Application No: AB/114/20/PD
Site Address: Riverside House 2 Fitzalan Road Arundel BN18 9JS
Description of works: Notification for Prior Approval under Schedule 2 Part 1 Class AA for a additional 2 storeys on existing dwelling house.

Objection to Planning Application
AB/114/20/PD
Riverside House
2 Fitzalan Road
Arundel
BN18 9JS

Drawing Title:
PROPOSED ELEVATIONS

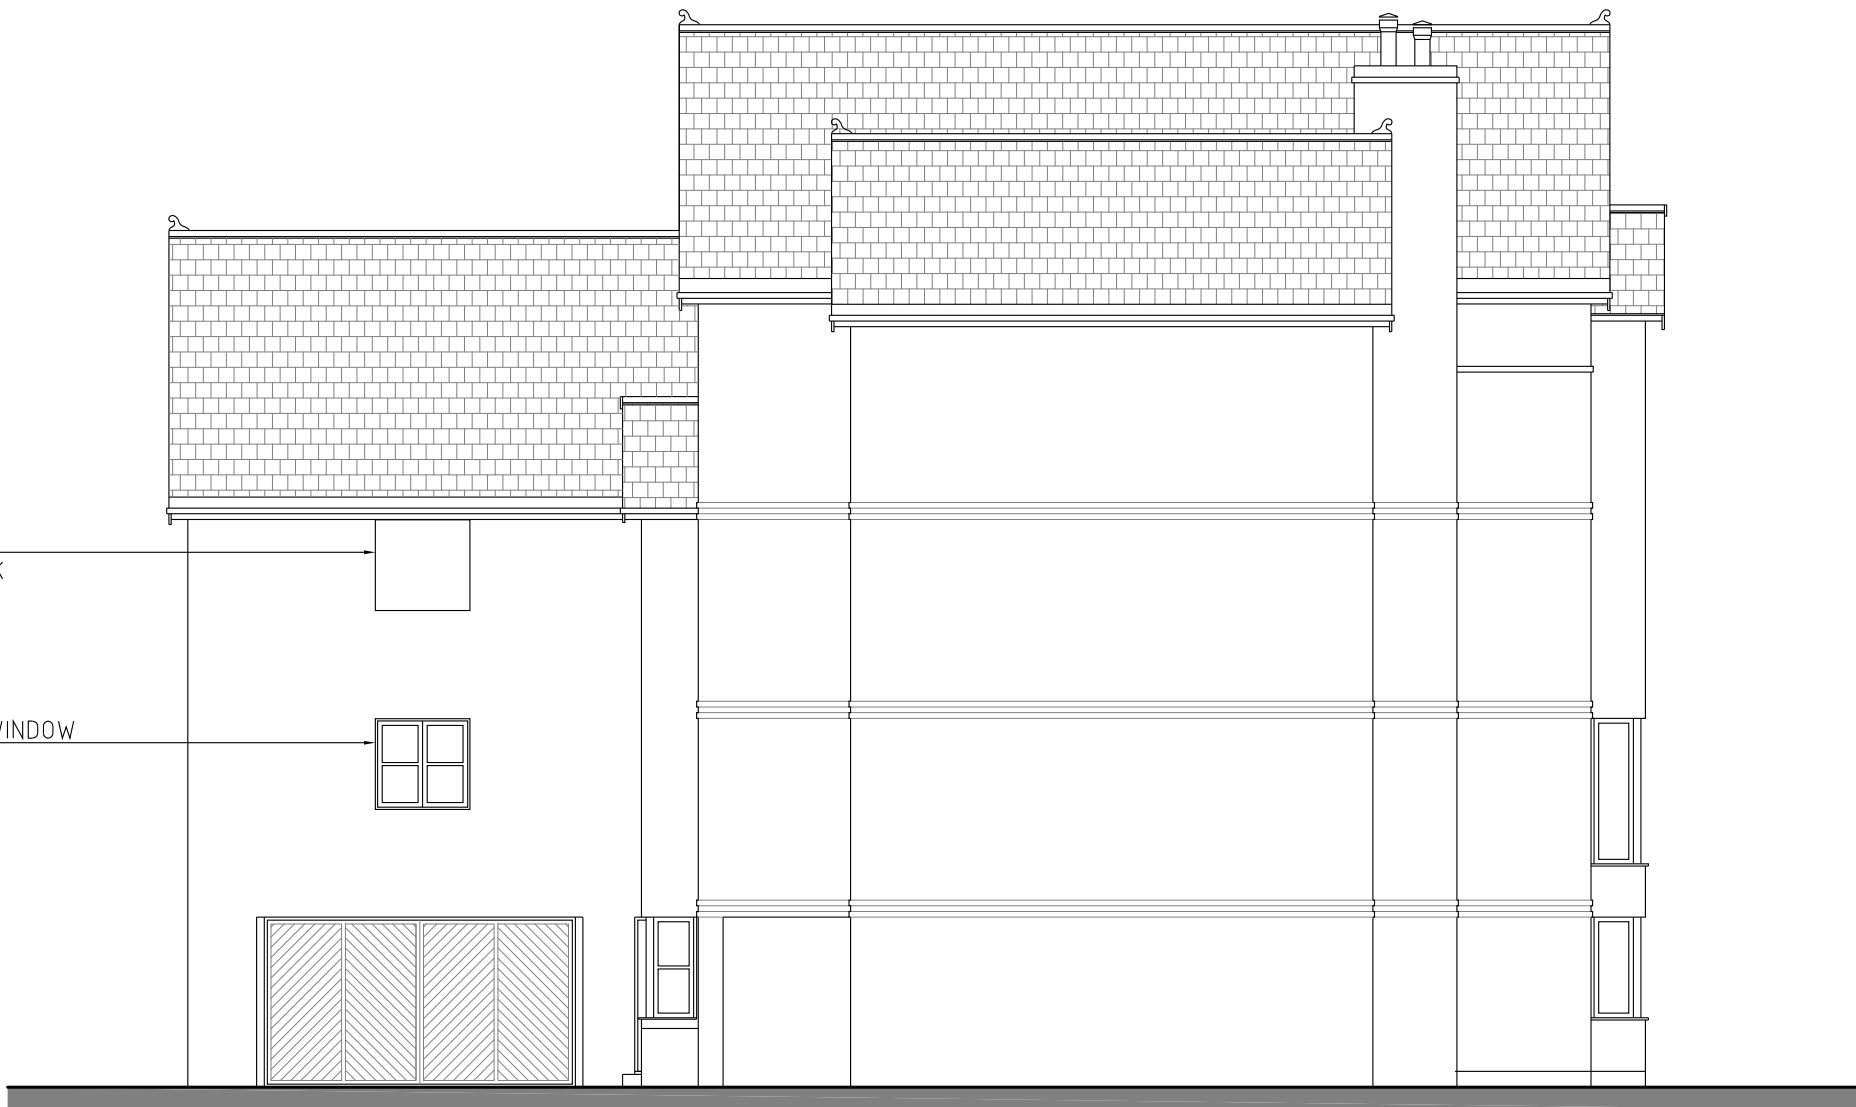
1. The proposed increase of two additional floors considerably raises the elevation, nearing the height of the Martlets Court building which in itself breached planning regulations when it was built. The relative height of Martlets should not therefore be used as a justification to increase the height of other buildings in the vicinity which is essentially a low-rise residential area.
2. The benchmark for new buildings should respect the other 2-story buildings of Fitzalan Road in keeping with the streetscape, or we set a dangerous precedent by gradually increasing building height along the east bank of the Arun.
3. The proposed elevation will obscure the view into and out of the Arundel Conservation Area, much to its detriment.
